Re Application ref: no. P/74/13

2 Lagoon road Pagham

As chairman of Pagham Beach Residents I wish to object to this renewed application because the dormer windows proposed will overlook properties on Well road. This is unneighbourly and contrary to the village design statement. Beach estate properties should be single story or the development should (as is the case with this property) not detract from the estate's special character. Incidentally dormer windows in the front should not have been allowed for the same sort of reasons.

REAR FENCE

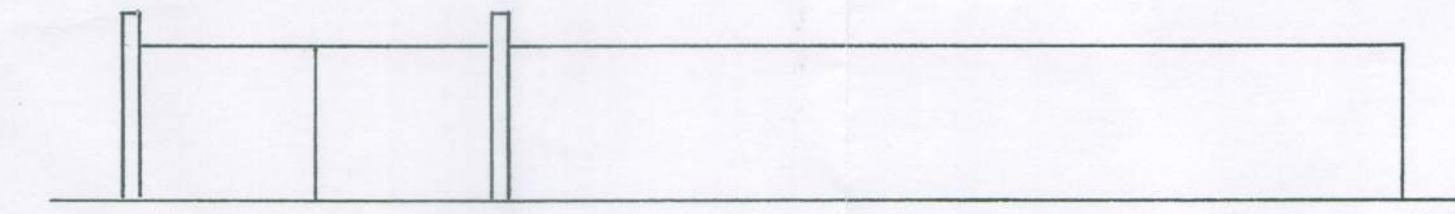
I also still wish to object to the fence and caravan erected behind this property adjacent to Well Road (Mentioned in my letter of 8th January 2013).^{*} The proposed replacement of this fence by a hard wall is a clear example of an insensitive boundary treatment inappropriate to the special character of the beach estate where soft boundaries and verges colonised by wild beach estate flora are more normal.

REAR WALL & GARAGE

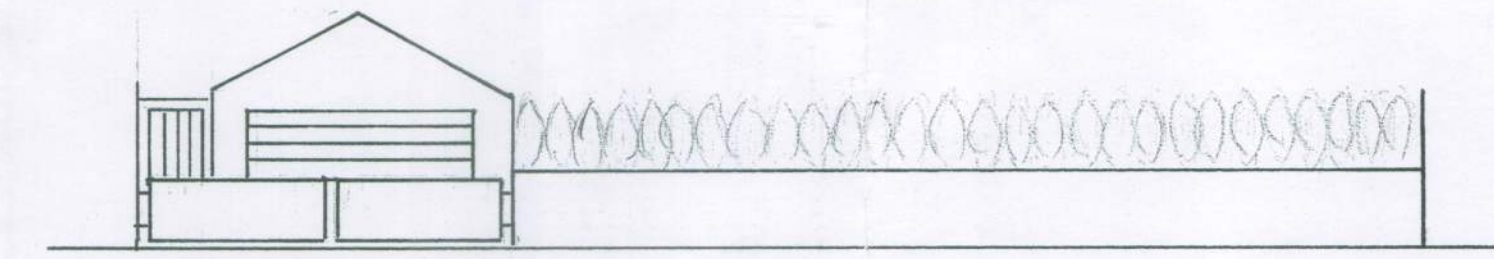
Is it reasonable to give planning consent when the fence or proposed wall are on Pagham Beach Holding's Land by two metres? Surely the ownership of the land must not be in dispute in order to grant planning permission?
